Planning Application Ref: BR/35/18/PL

Location : Car parking Site Adjacent to 112 Gravits Lane, Bognor Regis – Erect 2 No 2 Bed semi-detached house with associated parking and bin and cycle store provision.

Comments On Application:

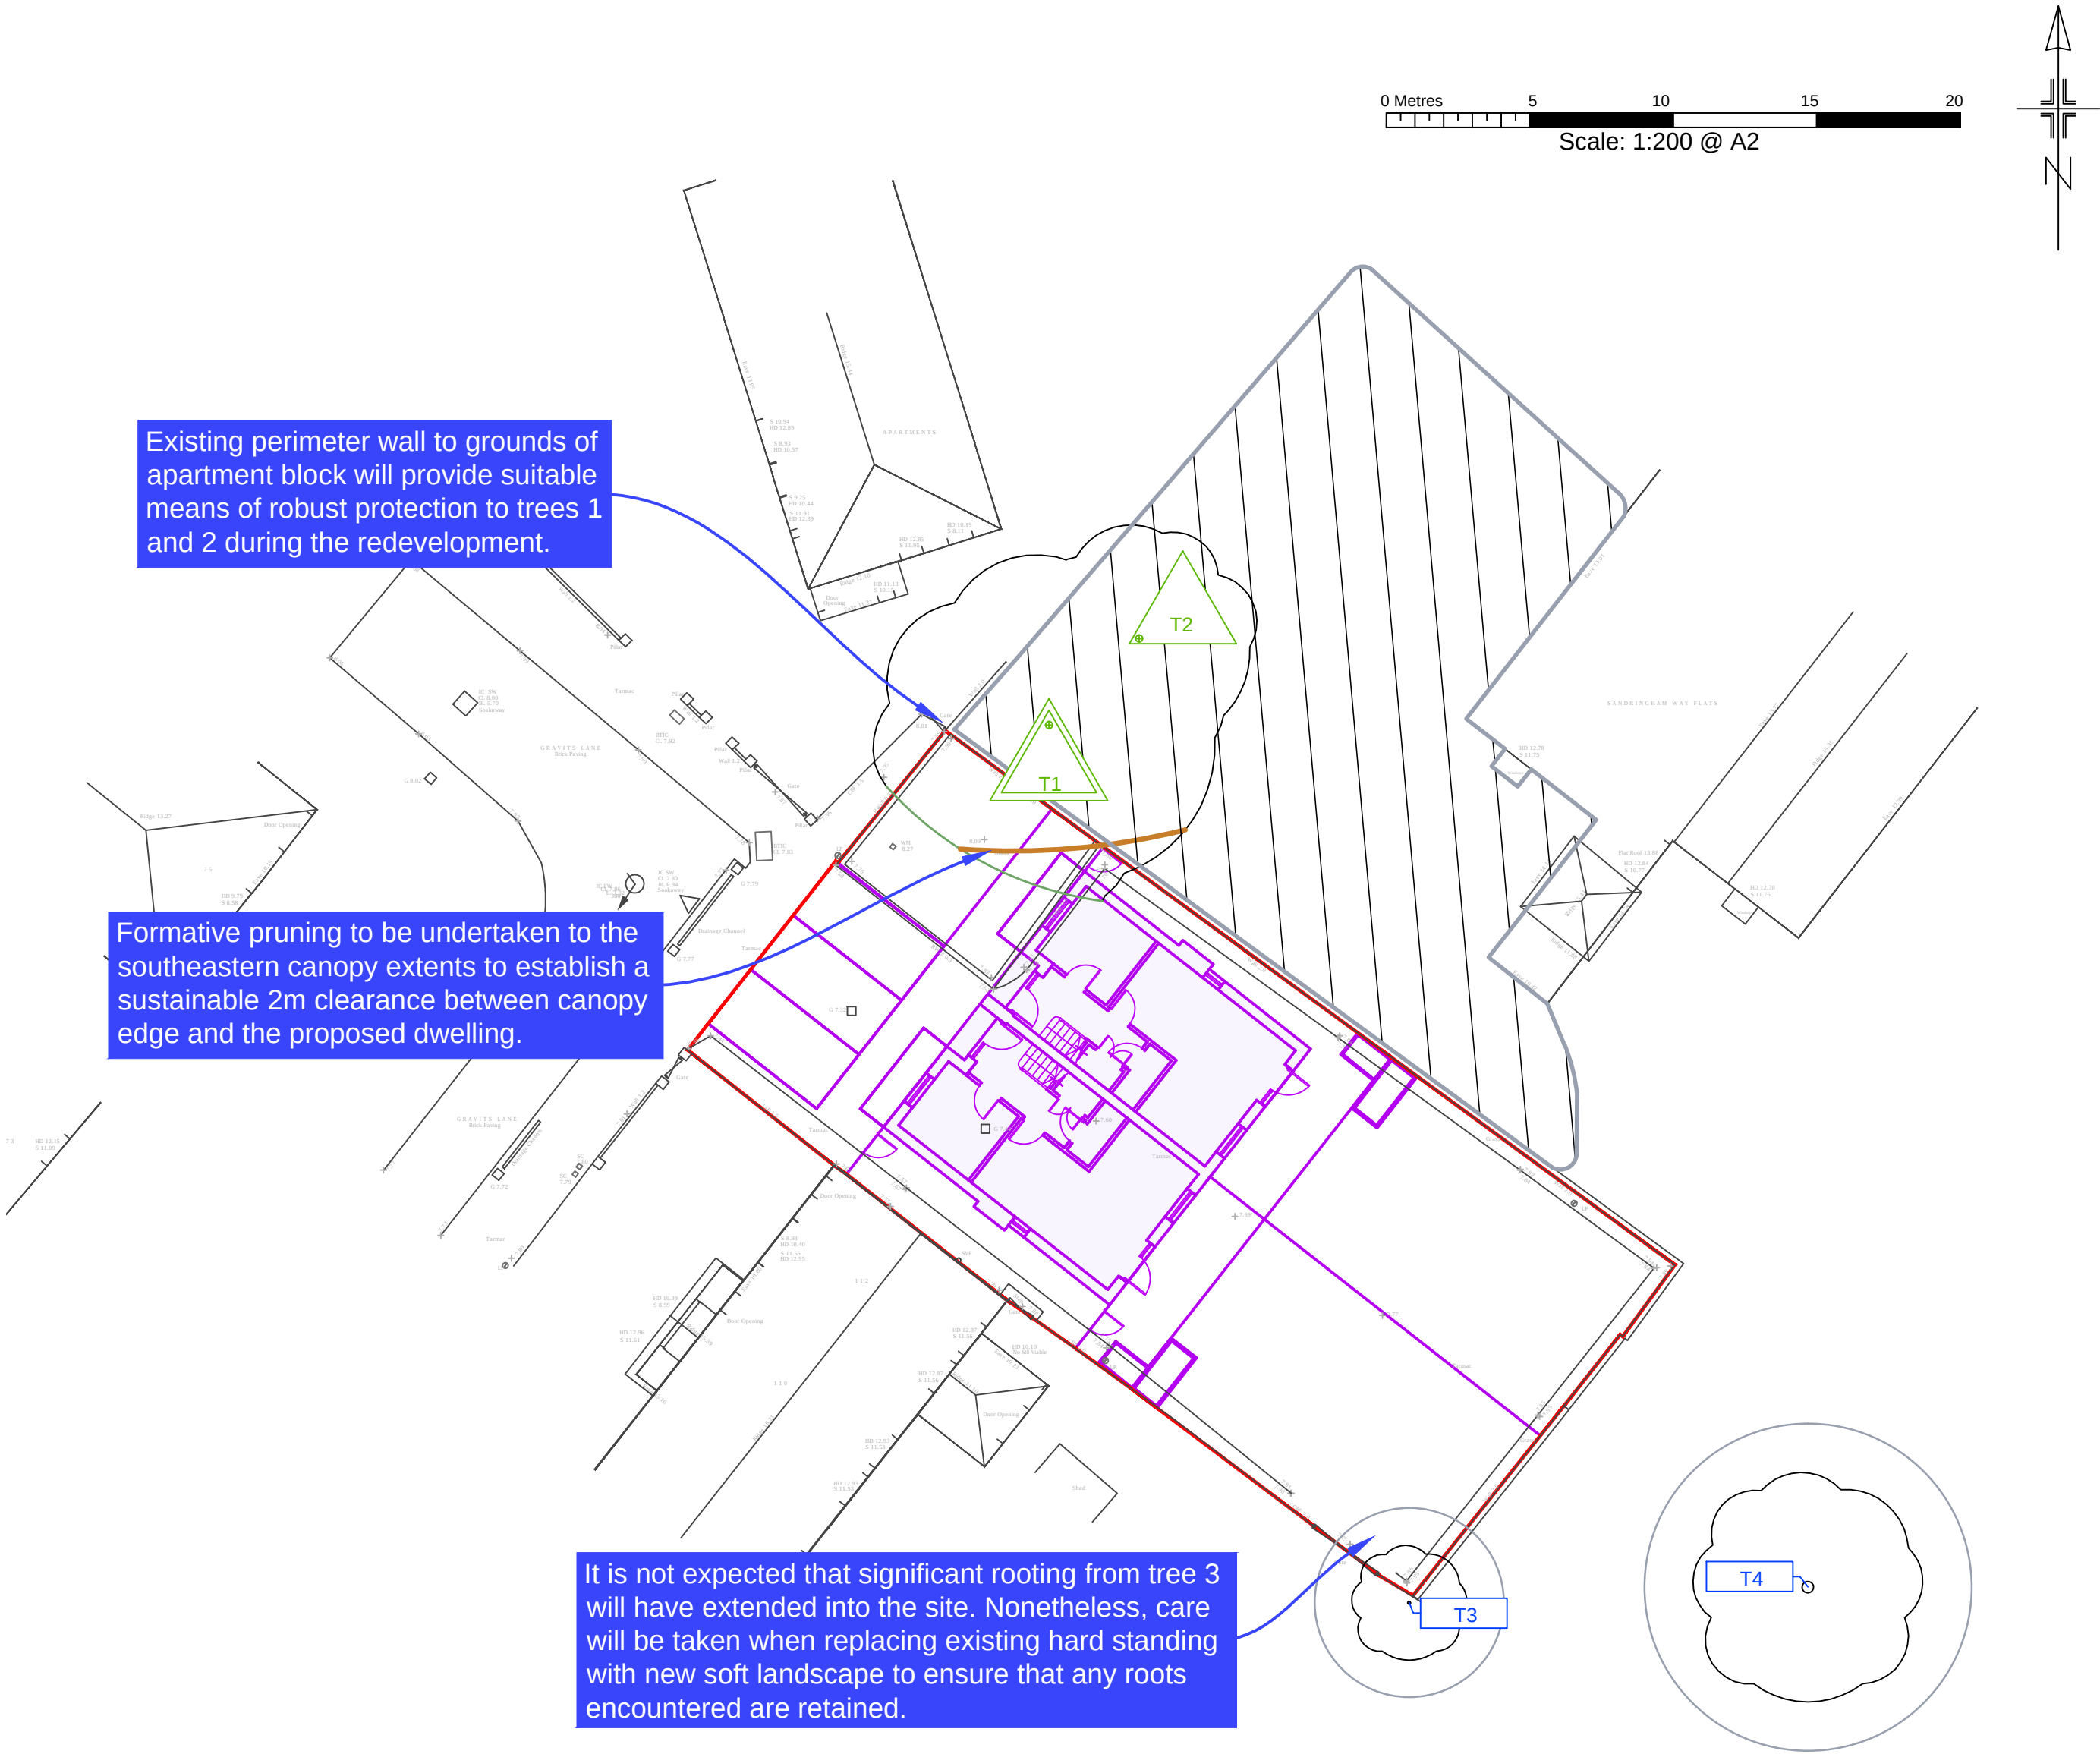
- Strangely it lists both the diameters and RPA's for the two C graded trees T3 & T4 but no such calculation has been shown for T1 or T2 and neither of the diameters are listed so I am unable to verify that the RPA's are correct.

- In the case of T1 & T2 it states 'see plan BT1'.

- As stated above the schedules do not list diameters or RPA's for T1 & T2 and reference to Plan BT1 shows only a note that states – ***'Existing perimeter wall to grounds of apartment block will provide suitable means of robust protection to Trees 1 and 2 during the development.'***

- I cannot agree with this statement as in my opinion the Holm Oak T1 will have easily defeated the footings of the wall and there will be roots well out under the existing hard surfaced car park.

- Until they apply the RPA's to T1 it is difficult to see if this would overlap the new buildings - but I suspect that this will be the case and significant harm could result to this tree.

- **IF** the RPA does overlap the building footprint and/or levels changes are planned within this trees CEZ then I would expect to see mitigation measures set out to ensure that no significant damage ensues to the root system of this tree.

- Currently no such measures have been stipulated and no protective fencing or ground protection has been proposed.
